MERIDIAN & REX RD
FA # / SITE ID:
10099189 / COL02090
10301 ANGELES ROAD
PEYTON, CO 80831

SHEET TITLE
ELEVATIONS

SHEET NUMBER
A3

Elevations_v1.pdf Markup Summary

SHEET TITLE
ELEVATIONS

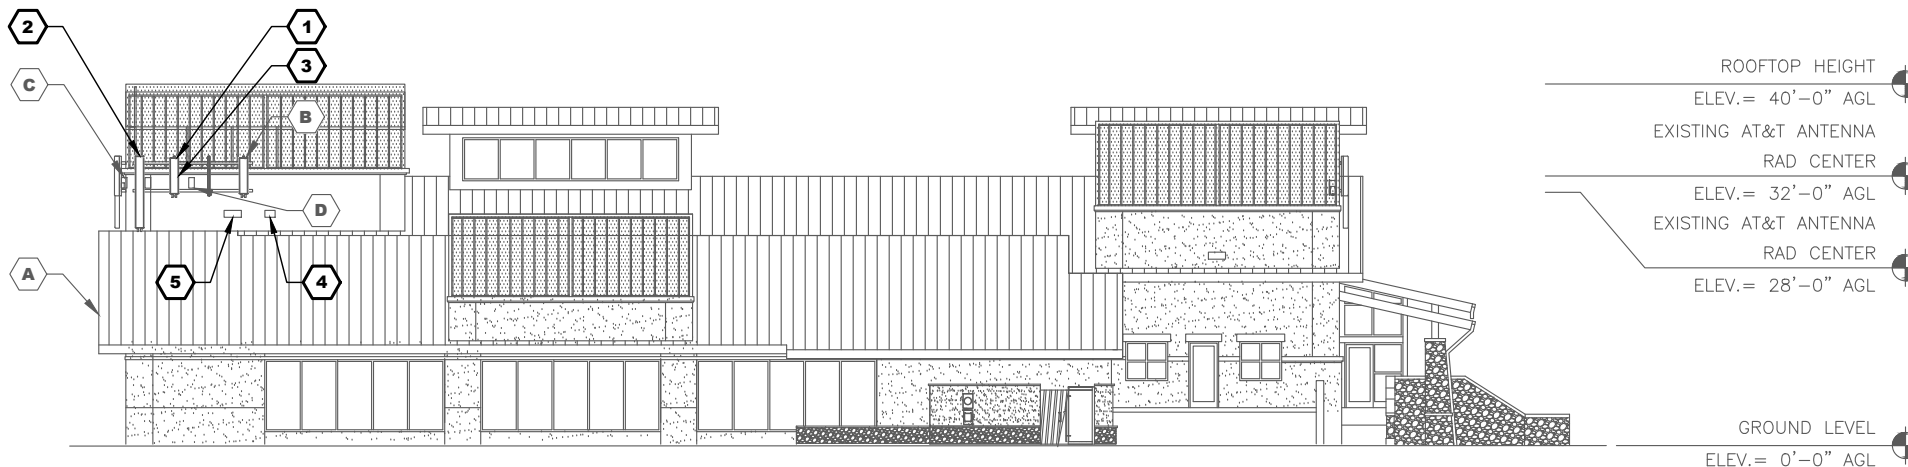
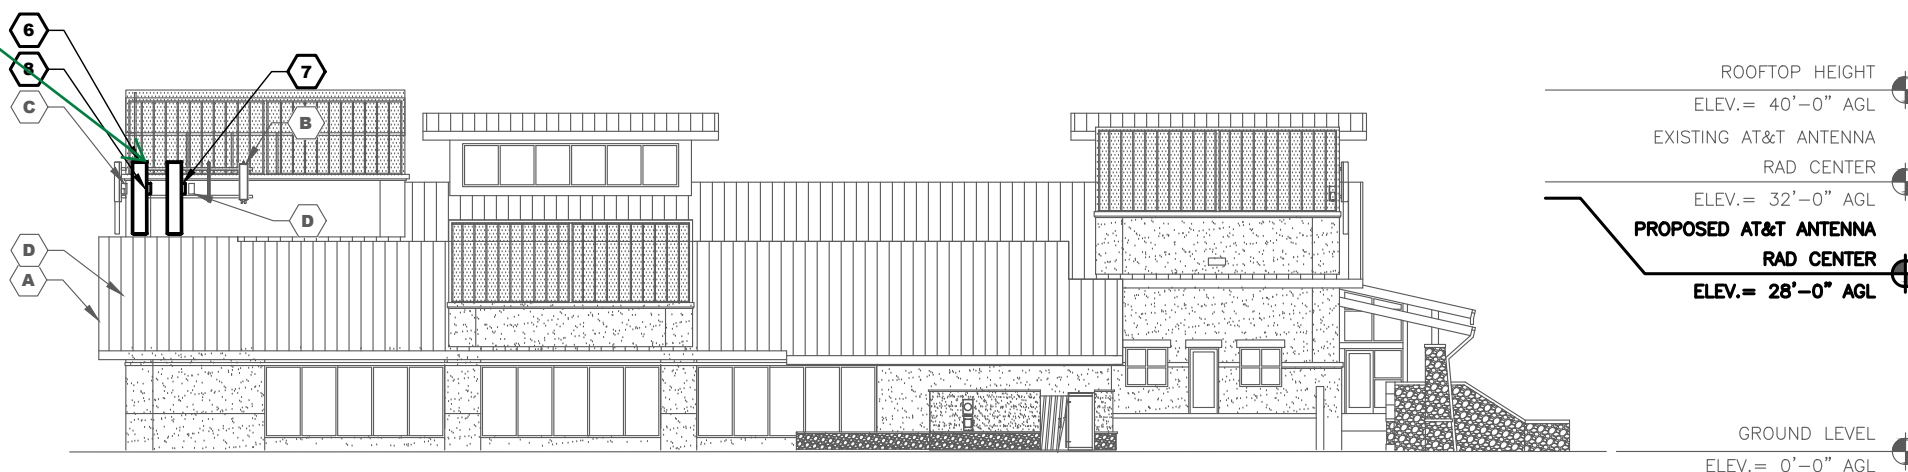
This equipment seems to be wall-mounted rather than rooftop-mounted, as such please include a detail / description of the color to verify that the proposed additions will be painted the same color as the building per requirements.
